Reinforcement to the North Shropshire Electricity Distribution Network

Document Reference: 6.6.7
Environmental Statement Appendix 6.7
LVIA Scoping Opinion Responses

APPENDIX 6.7: LANDSCAPE AND VISUAL ASSESSMENT RESPONSE TO SCOPING OPINION

CONTINUES ON PAGE 4 OF 5

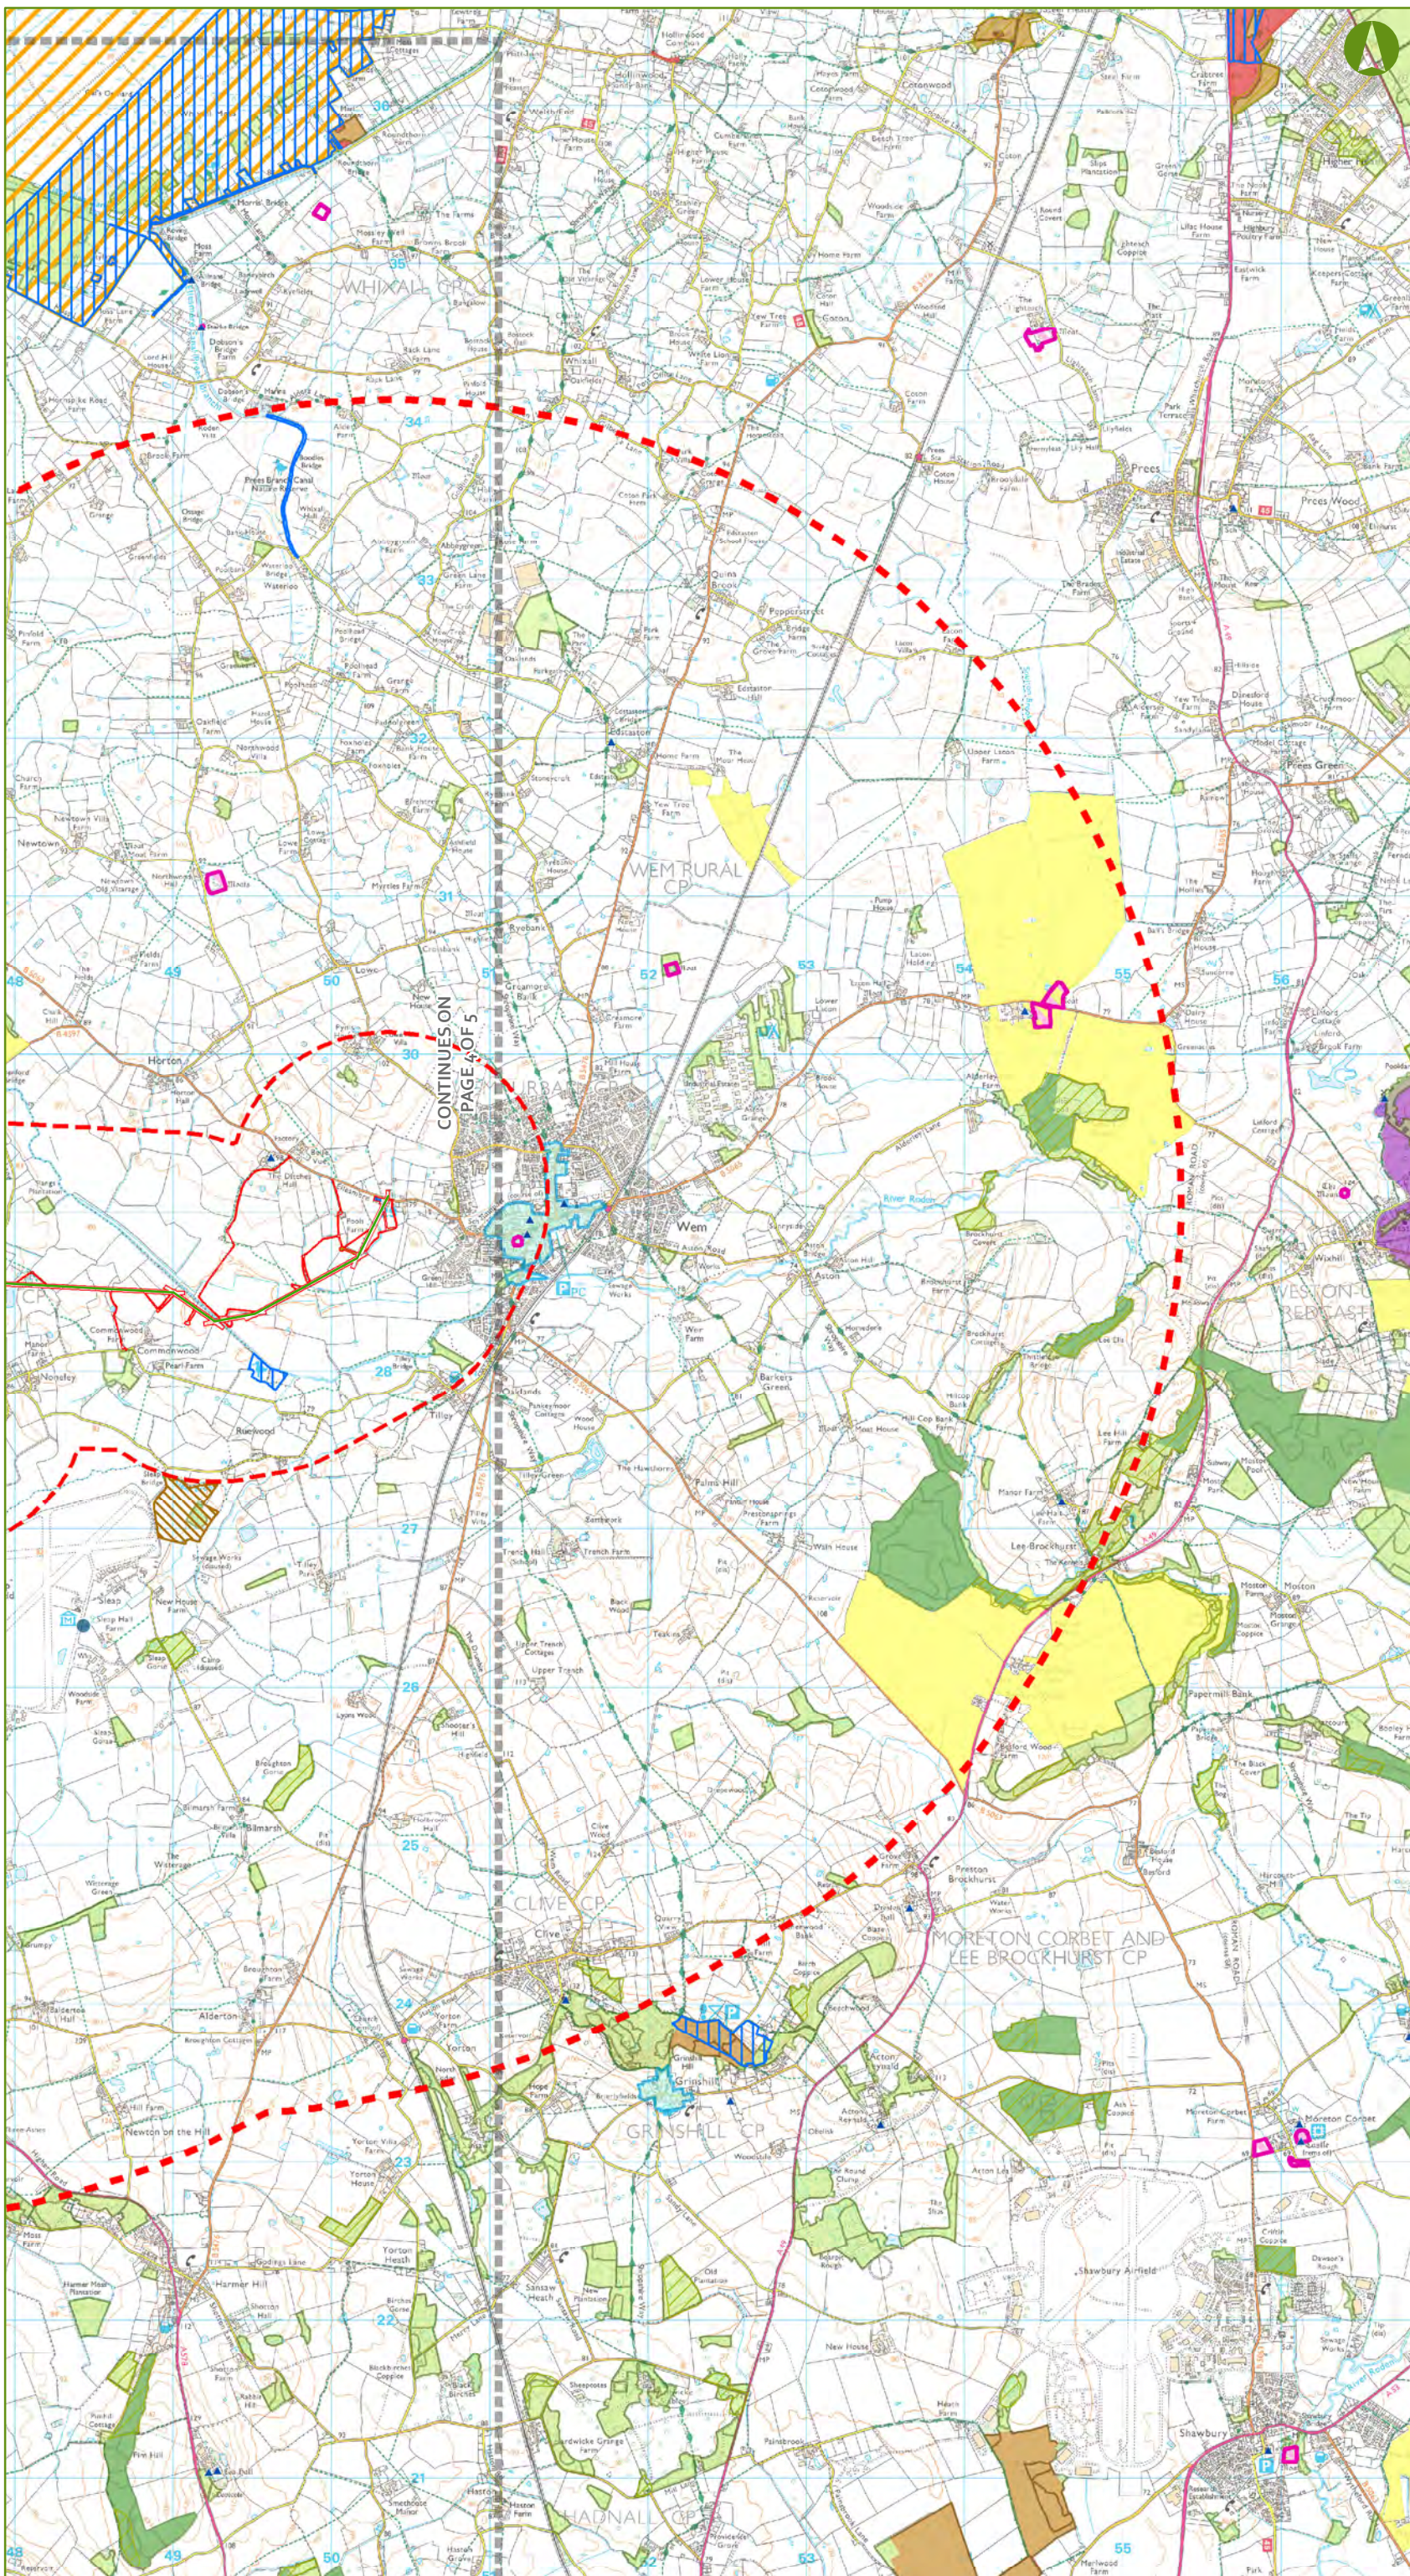
3.36	Paragraph 7.5.12 identifies a number of designated and non-designated sites. It would be helpful if this information was provided on plans in the ES to aid understanding of the features in the area that contribute to landscape character.	This information is presented within Figure 6.4 ‘Landscape Receptors’ (DCO Document 6.14) and Figure 6.6 ‘Public Rights of Way and Areas of Open Access’ (DCO Document 6.14) of the ES.

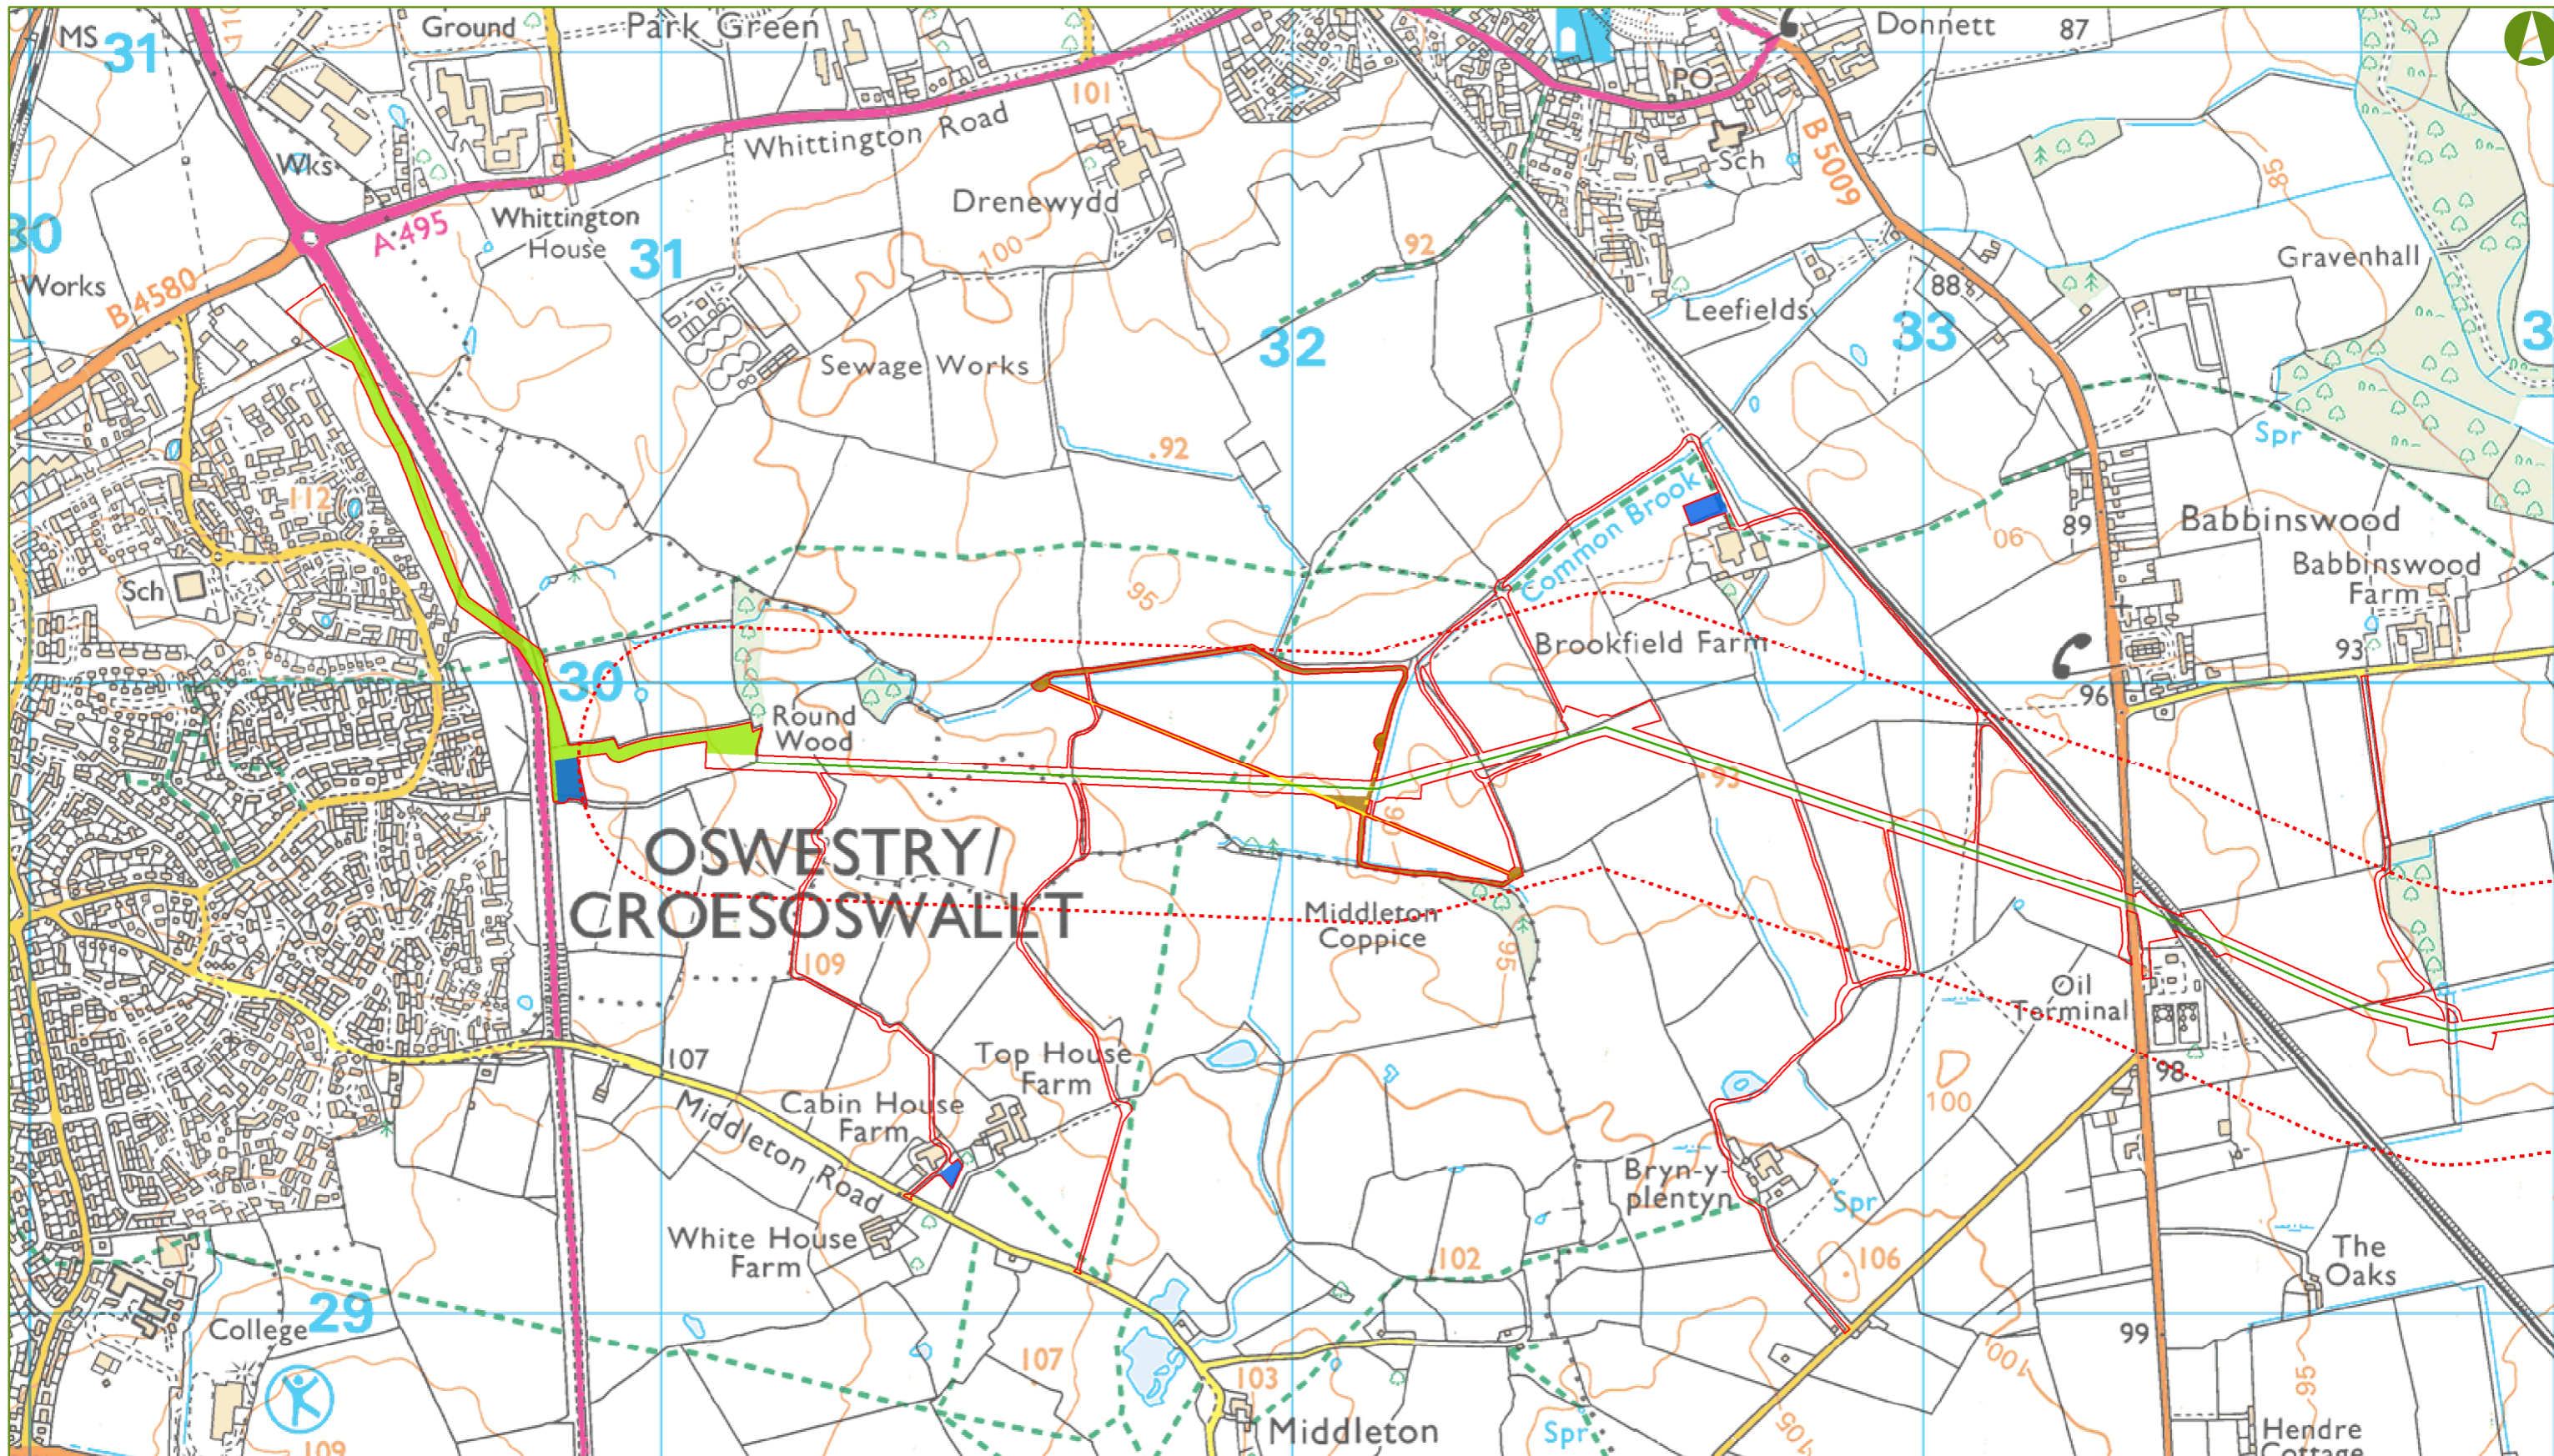
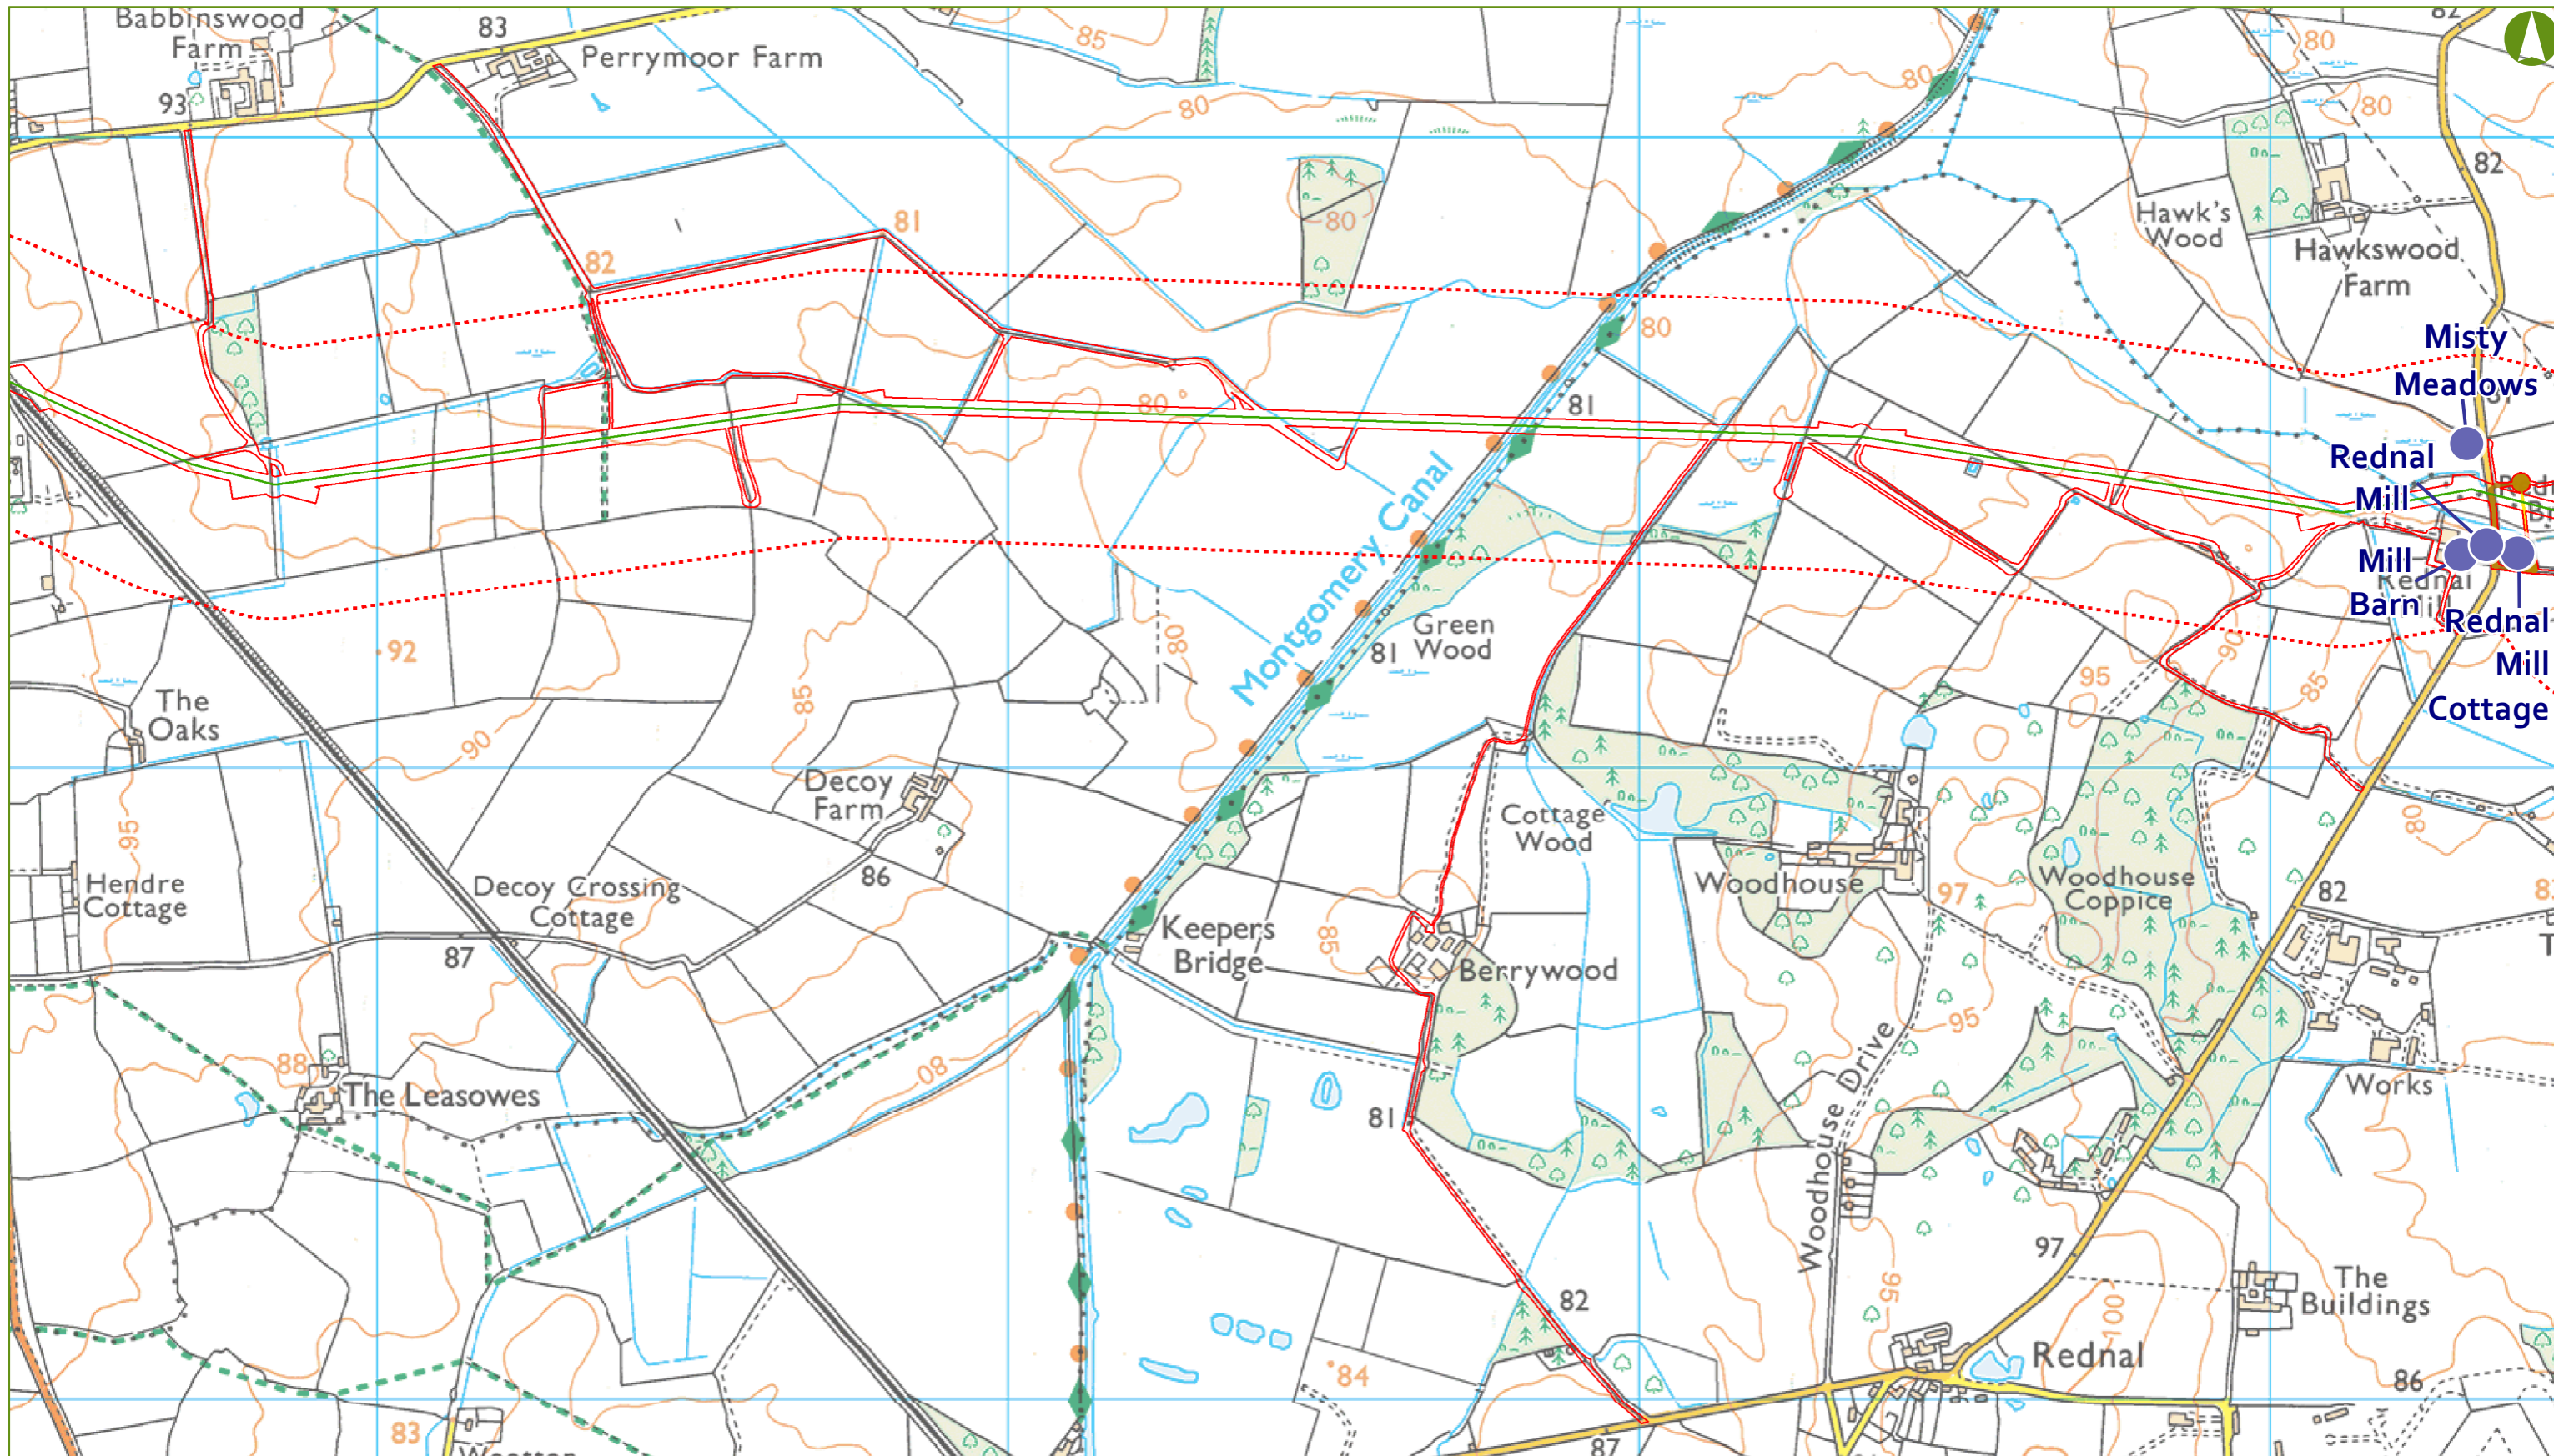
3.47	In addition to the study areas referred to above, paragraph 8.7.24 notes that a residential amenity assessment will be undertaken with a 200m study area either side of the overhead line. The study area should extend from the limits of deviation of the route corridor. This study area does not appear to be depicted on a plan. Such a plan would assist the reader, and it would also be helpful if the selected viewpoints were depicted, especially where particular exceptions have been made and the study area broadened.	The study areas do extend from the Order Limits and are all presented on Figure 6.1 ‘LVIA Study Areas’ (DCO Document 6.14). All viewpoints are presented on Figure 6.8 ‘Viewpoint Locations’ (DCO Document 6.14) and also on Figure 6.5 ‘Topography – Elevation’ (DCO Document 6.14).
